Application No: AL/84/21/PL
Site Address: Innisfree 26 Belle Meade Close Woodgate Aldingbourne PO20 3YD
Description of works: Variation of condition 2 imposed under AL/23/20/HH relating to approved plans.

Thank you for your internet representation made on 11th July 2021 which has been recorded as an objection with the comments as follows:

PROPOSED REAR EAST FACING ELEVATION

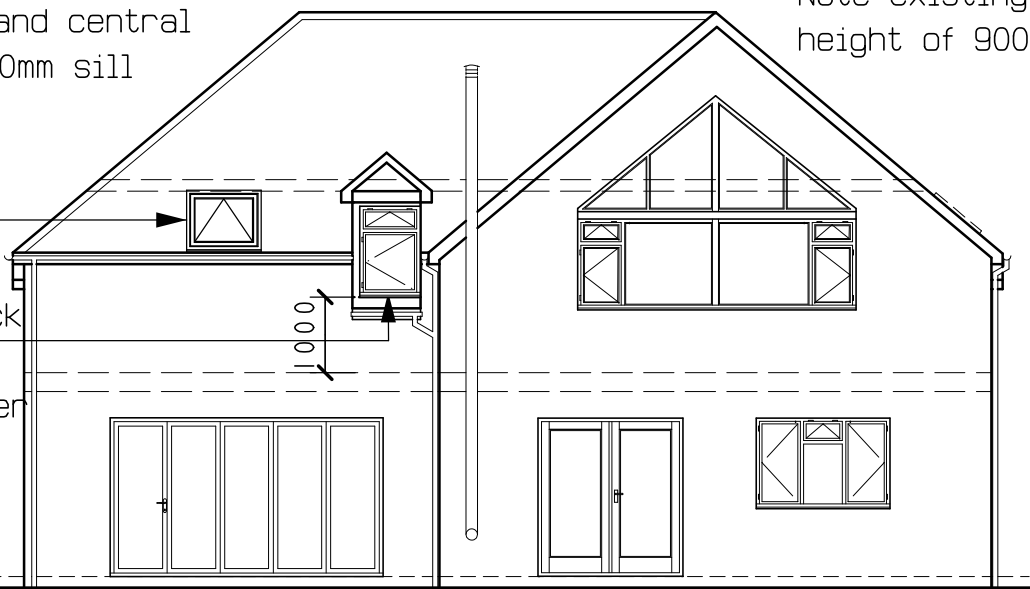
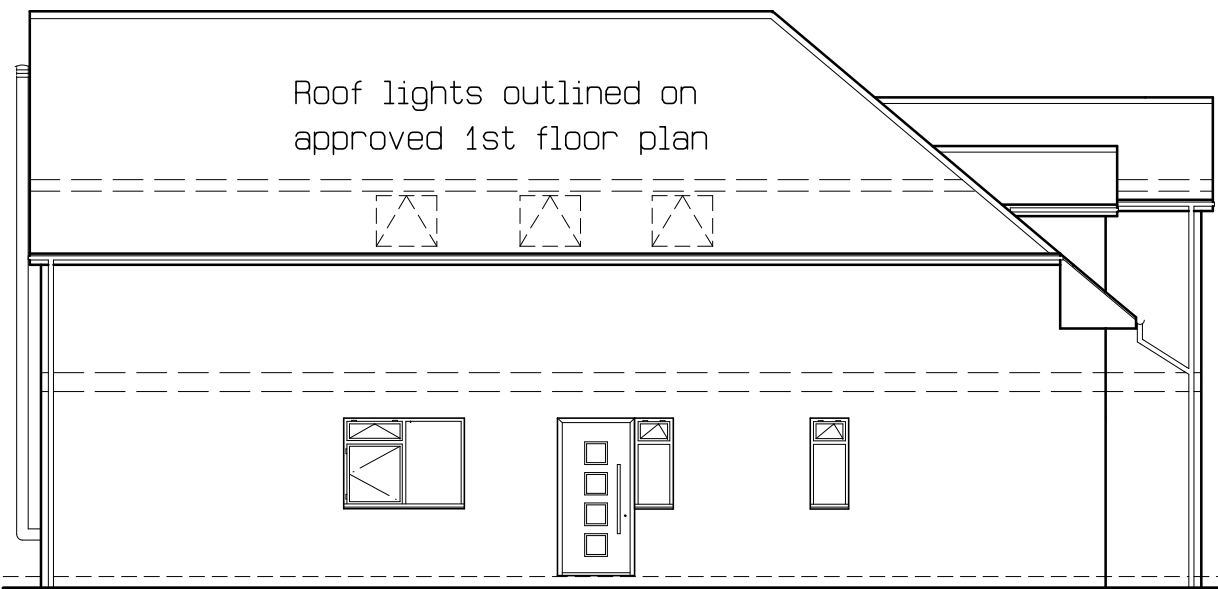
Specifically the implementation of the rear dormer window, which was initially refused, and the addition of a Velux style window in the same bedroom contrary to approved plans. The proposed argument is that this change is required under the guise of building control requirements, if indeed this is valid for the Dormer window given there are now two closely coupled windows to navigate for fire escape purposes which according to Building Regulations B1 could be considered an obstruction. When my wife initially approached the builder about the non compliance she was told by him that the Dormer construction was purely in the interest of aesthetics.

The behaviour of this Builder and Architect with regards to their non adherence to the approved plans, the statements and submitted plans to make the Dormer window justifiable, feels untenable given the current external implementation and reliance on an internally affixed window to guarantee our privacy. The updated plans for the Dormer window makes it easier to remove the internally constructed window at a future date, if indeed it is ever installed in the first place. The only way to validate if they are adhering to the revised plans and design would be via an internal inspection which the builder and architect know is unlikely to happen.

As our original privacy concerns for the Dormer window were considered valid resulting in revised plans with the Dormer removed being approved by the Planning Officer I would like to know now why this is no longer the case given the NMA approach without verifying the designs and validating the implementation.

As it appears from the submitted statement that the preferred and initially supported route for the planning breaches was a NMA for which I would have had no opportunity to comment I have been asked by the Local Government Ombudsman to follow all ARUN's comment and complaint processes with regards to this development, hence this objection to the East Dormer and Velux implementation.
